City of Portland, Maine - Building or Use Permit Application

Job No: 2012-10-5202-DRG	Date Applied: 10/17/2012	CBL: 109B- B-018-001 & 109B B041	
Location of Construction: 142 SUNSET RD, CLIFF ISLAND	Owner Name: CAROLYN L LIFE INT RIDEOUT	Owner Address: PO BOX 98 CLIFF ISLAND, ME 04019	Phone: 207-766-0009
Business Name:	Contractor Name: SELF	Contractor Address:	Phone:
Lessee/Buyer's Name:	Phone:	Permit Type: BLDG - Building	Zone: IR-1
Past Use: Single family home	Proposed Use: Same – single family home – build 12' x 20' boathouse/shed	Cost of Work: 6000.00	CEO District:
		Fire Dept: <input type="checkbox"/> Approved <input type="checkbox"/> Denied <input type="checkbox"/> N/A	Inspection: Use Group: Type:
		Signature:	Signature:
Proposed Project Description: Build a 20' x 12' boathouse/shed		Pedestrian Activities District (P.A.D.)	
Permit Taken By: Brad		Zoning Approval

Re: 142 Sunset Road, Cliff Island – 109B B018 & 109B B041 – IR-1 Island Residential Zone – permit #2012-10-5202 – 20' x 12' boathouse/shed

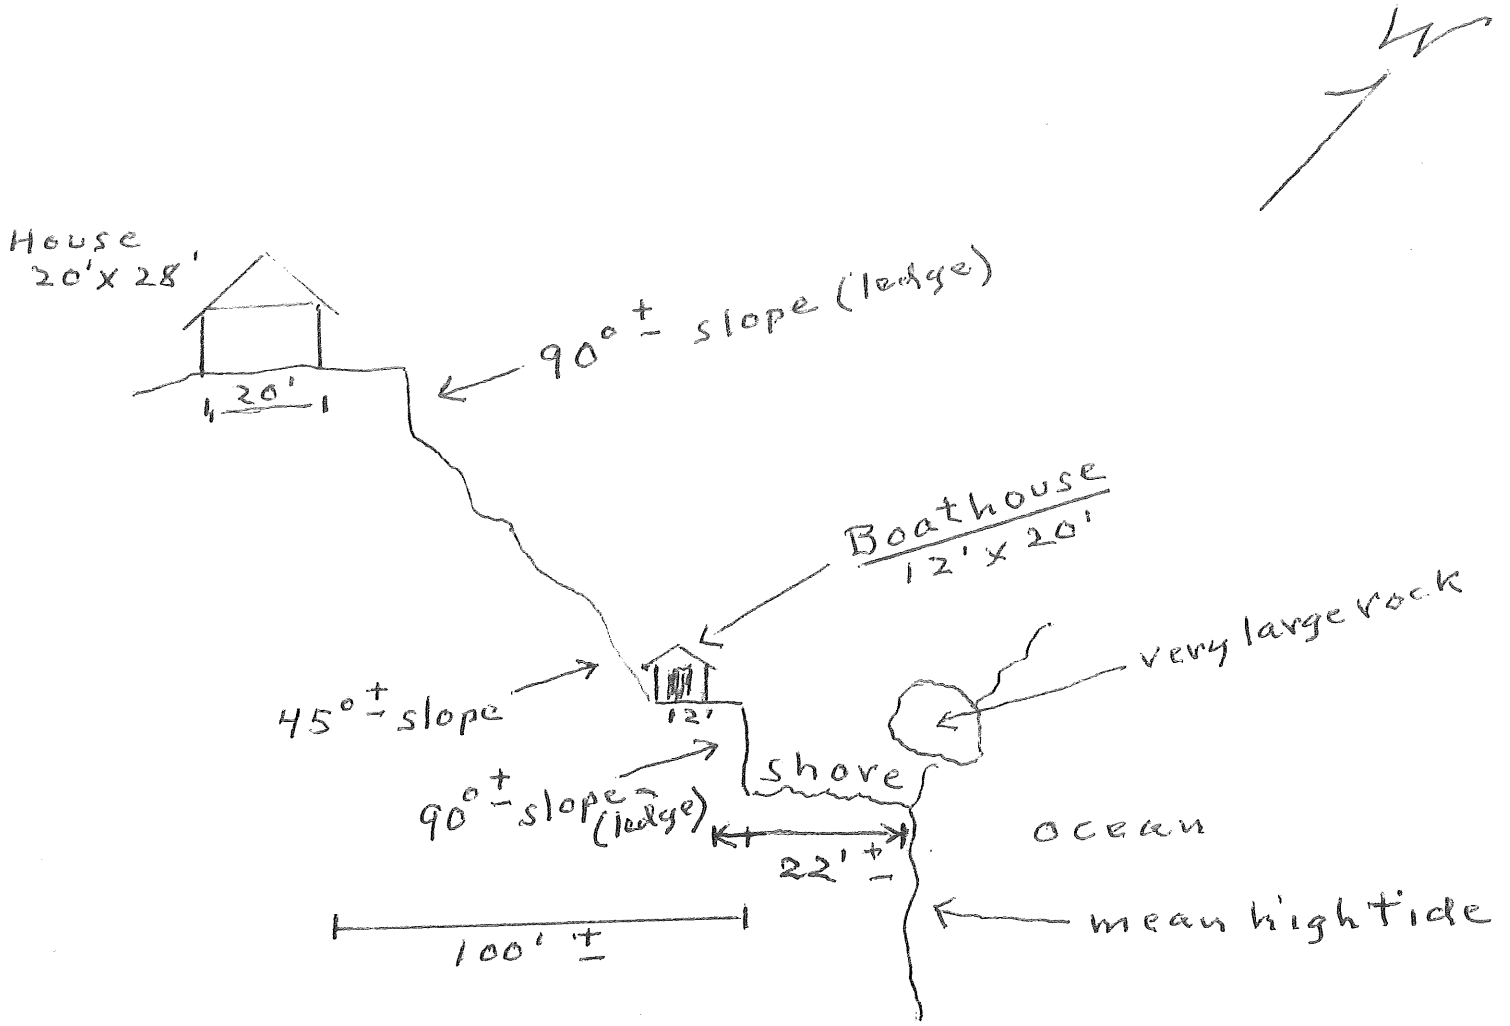
10-17-12 The dimensions on the plot plan do not match the dimensions on the deed provided. The applicant is claiming a strip of land on the left side of the property that is 24'9" wider than what the deed says (76'5" claimed, 51'9" on deed). As a result the proposed boathouse does not meet the side yard setback of 20'. The required rear setback is 30'. The plot plan gives 22' to the high tide which is beyond the rear property line. Also the proposed shed falls within the 75' setback from the highest annual tide and since it is greater than 100 sf and not just for "storage of fish, bait, and related equipment" [section 14-449(a) (1)] it cannot be located within the 75' setback. -amachado

The proposed boathouse/shed does not meet the rear or side setback requirements of the IR-1 zone. The required rear setback is thirty feet, and the required side setback is twenty feet [sections 14-145.5(c)(2) & 14-145.5(c)(3)]. The distances that you provided on the plot plan for the size of the lot do no match up with the distances on the deed (Book 13073, Page 233) that you provided. Your plot plan gives the distance of the lot along the northerly side of the cemetery as a total of 76'5". The deed gives this distance as 51'9". In other words your left side property line is 24'8" closer to the house then shown on the plot plan. Instead of having the 32'1" that you gave on the plot plan as the side setback to the shed, you only have 7'5". This does not meet the required 20' side setback. You have not given the distance from the shed to the rear property line. You have only shown the 22' to the mean high tide which is beyond your rear property line, so the proposed shed is less than 22' to the rear property line. Since the proposed shed is not meeting the required 20' side setback and the 30' rear setback, the permit is denied.

Your property also falls within the Shoreland Zone. Section 14-449(a) states that "all principal and accessory structures shall be set back at least seventy-five feet horizontal distance, from the normal high water line of water bodies". Your plot plan gives the distance for the mean high tide as twenty-two feet. Your proposed shed does not meet this condition, so the permit is denied.
